From: Christina Wollman
Sent: Thursday, August 07, 2014 10:14 AM
To: Kaycee Hathaway
Cc: Jeff Watson
Subject: floodplain layer

The Erdman parcels are not in the 100-yr floodplain. The data you are using is incorrect.

**Critical Area**  
**Map**

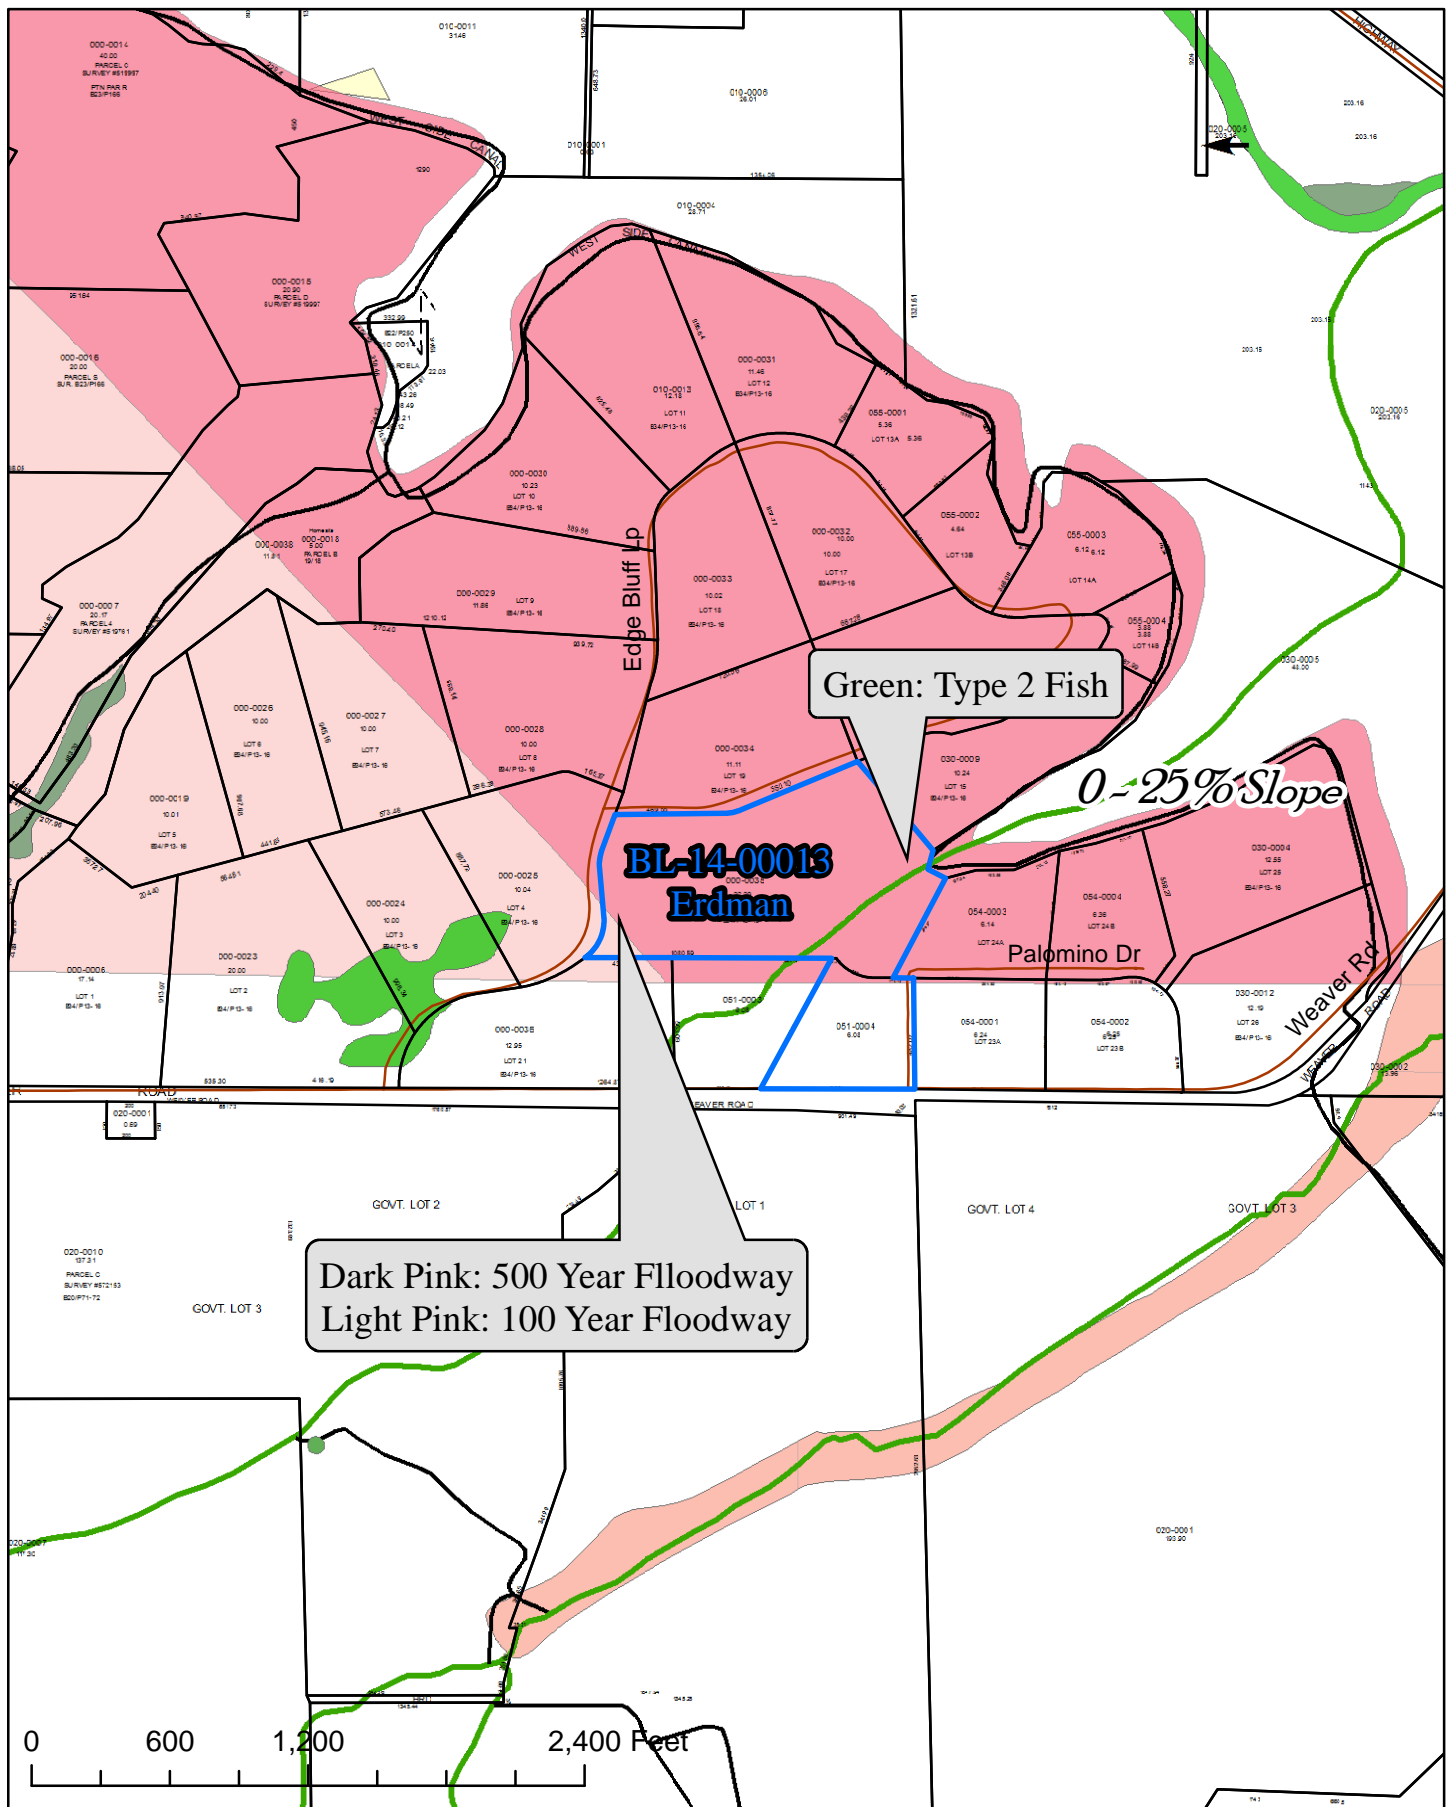
Please use the layer file called "FIRM Floodplain with floodway"
